VERIFICATION AND COMPLIANCE

GREENFIRE SOLUTIONS

FEN DYKE FARM, BARDLING'S DROVE,

OCTOBER 2024

Appendix A – Proposed Site Layout

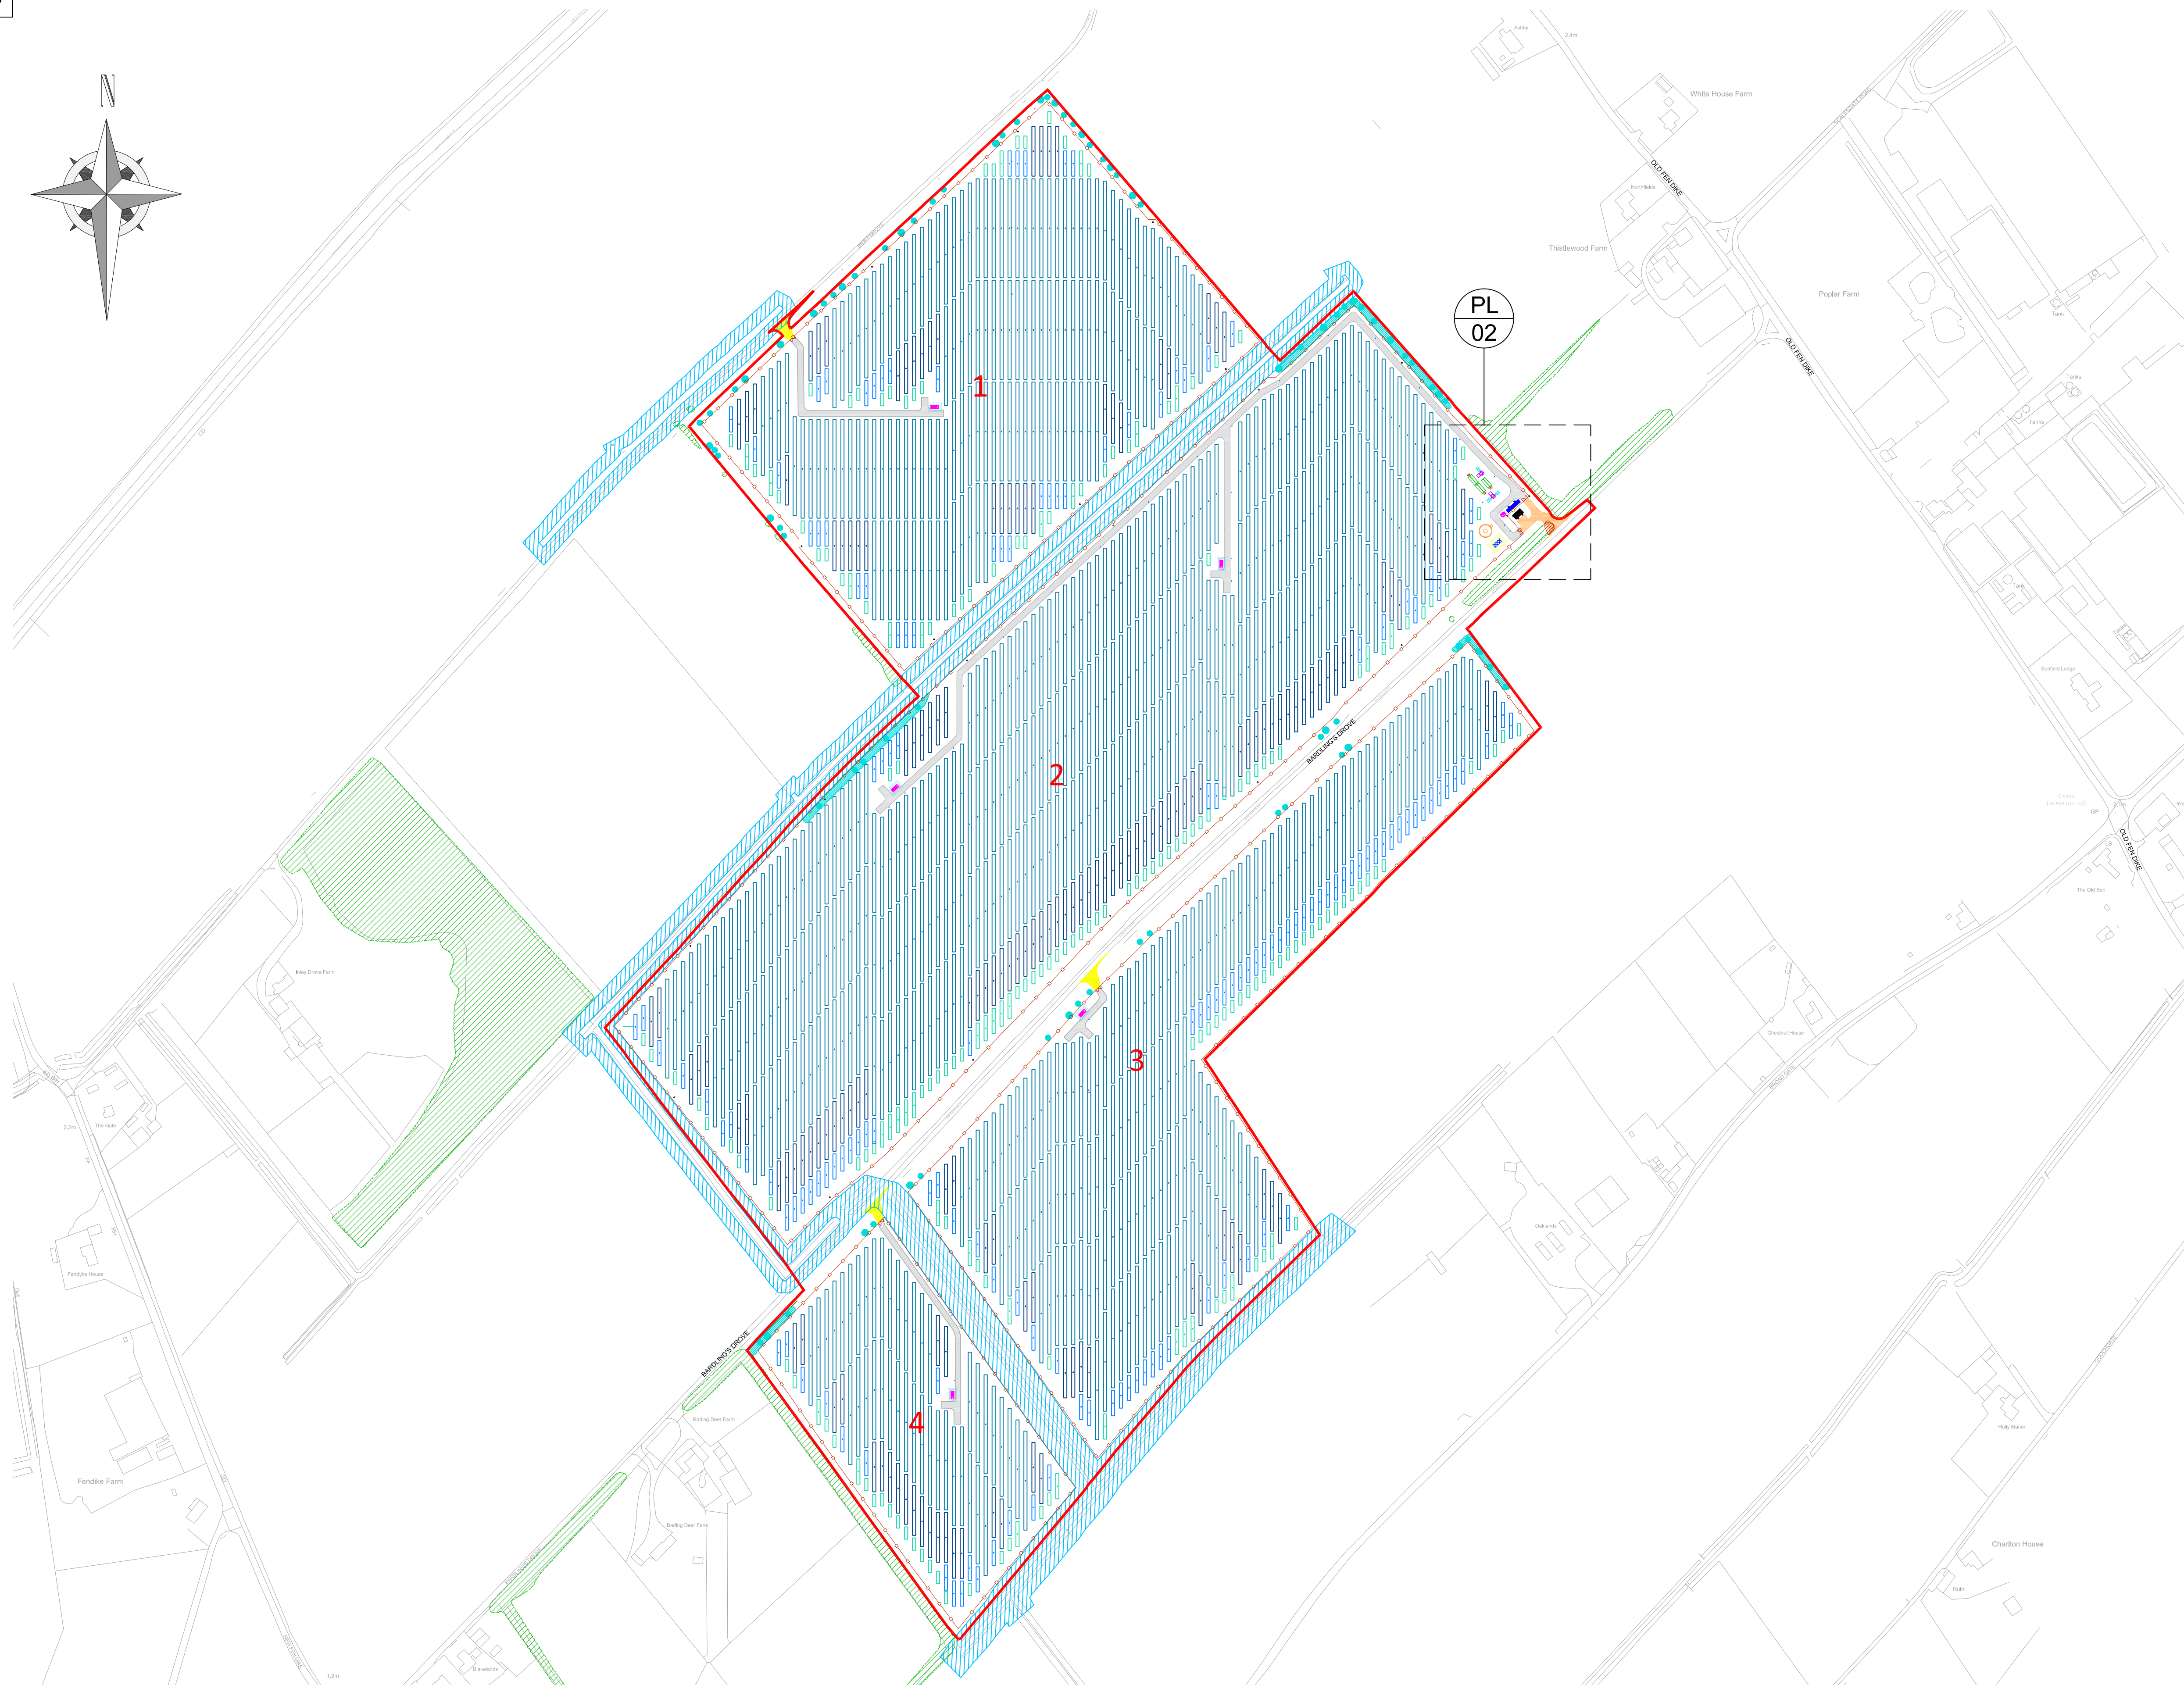
- 3.17 Greenfire Solutions note that the side-to-side separation between the BESS units is 2.5m and that each pair are arranged back-to-back, as shown in the diagram shown in *Appendix 2*. Greenfire Solutions confirm that, as per NFPA 855:2023 G.9.2.2, the separation distance can be less than 6m if the units have at least a 60min thermal barrier. The separation distances and this design is in

6.2 The Layout Plan Detail at *Appendix 1*, shows that the fire and rescues service will be provided with an emergency water supply via an onsite tank which has a minimum capacity of providing 228,000 litres (1,900L/min for at least 120 minutes). This tank will be sited at least 10m from any BESS container and will be connected and pumped to any affected BESS unit via a fire service appliance. Greenfire Solutions agrees that this is an appropriate supply of water and meets the NFCC guidance on BESS sites.

6.3 From the information provided to Greenfire Solutions by Integrum to date, there is limited evidence to support fire and rescue service access to the site and whether this complies with Approved Document B5 in terms of distance between kerbs, turning circles, access routes around the site including a swept path analysis. A single access road is shown on the scheme design. Whilst

the NFCC Guidance suggest two access routes, Greenfire Solutions acknowledge that is this a small site (10MW) so one access road may be operationally acceptable to the fire and rescue service.

Assessment Criteria 7: ***As part of the planning application, Integrum should provide details of the vehicle access path around the site and confirm that the design, construction and maintenance of the road are suitable for fire service vehicles.***
